## H2Teesside DCO Examination

### South Tees Group (20049389) – Deadline 2 Submissions

#### Written Representations and Response to Deadline 1 Submissions

Plate 4-2: Water Management Options (Indicative)

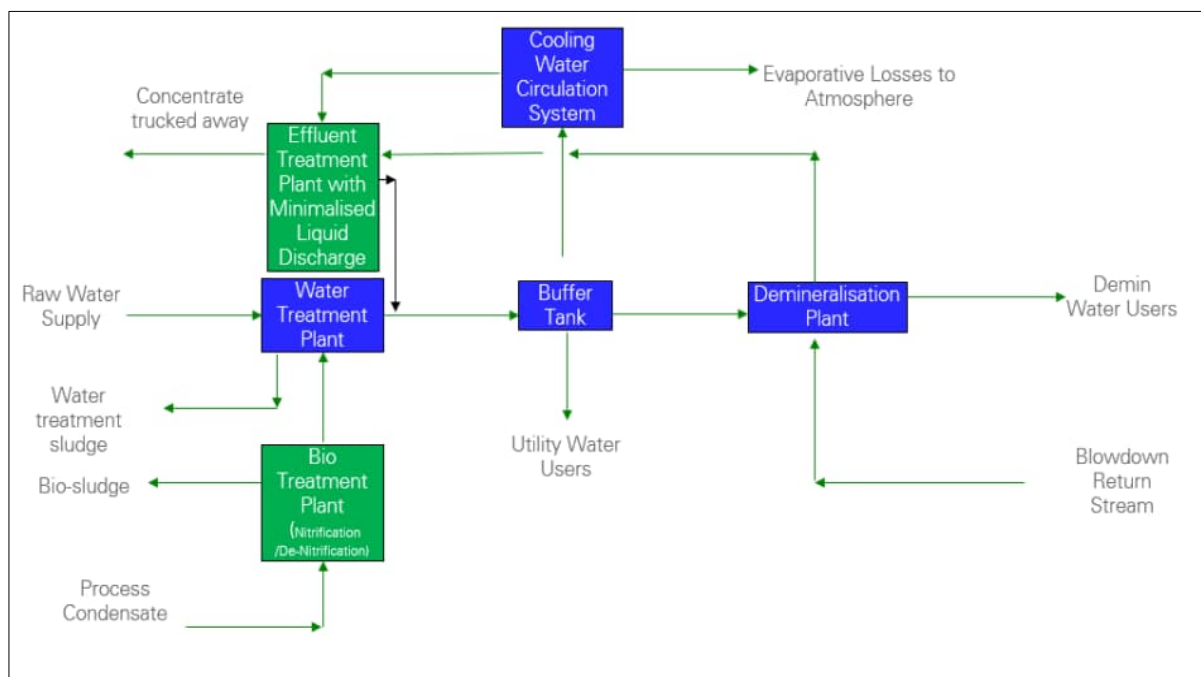
<p>The ES states that an Effluent Treatment Plant will be constructed, which will consist of an oily water separator, neutralisation sump, storm water sump and any other suitable treatment to meet agreed discharge standards. All oily water effluents produced by the Hydrogen Production Facility will</p>	<p>Case 1B (Minimalised Liquid Waste from the ETP) is no longer proposed by the Applicant, as such Case 2B (discharge of effluent to Tees Bay via the NZT outfall) will be progressed. Therefore, effluent will be treated to an appropriate level associated with the use of Best Available Technique and</p>	<p>STG notes that the option – Minimalised Liquid Waste from the ETP – is now no longer proposed by the Applicant and that, instead, the remaining option – use of the NZT outfall – is to be utilised.</p>

<b>STG's RR issue</b>	<b>Applicant's comments</b>	<b>STG's response</b>
<p>be sent to the oily water separator. For post separation, there are currently two options considered where the liquid effluent will be sent. The first option is to send liquid effluent to Minimum Liquid Discharge Plant on the main site, that may consist of ultrafiltration and Closed-Circuit Reverse Osmosis . This plant will produce a stream of clean water that will be reused in the hydrogen production plant and a brine stream that will be tankered from site to a suitable third-party disposal site. The second option is to treat this effluent to an appropriate level associated with the use of Best Available Technique and disposed of via the NZT outfall that is to be built as part of the NZT DCO development. Any solids will be sent for disposal offsite.</p> <p>There is limited information on the potential quantity of brine steam that will be tankered offsite for disposal by a third party or the quantity of any solids that will be sent for disposal. The South Tees Group requires further detail in respect of both options in order that it can understand the potential for highways impacts associated with both options.</p>	<p>disposed of via the NZT outfall that is to be built as part of the NZT DCO development.</p>	<p>STG's previous concern is therefore now addressed.</p>
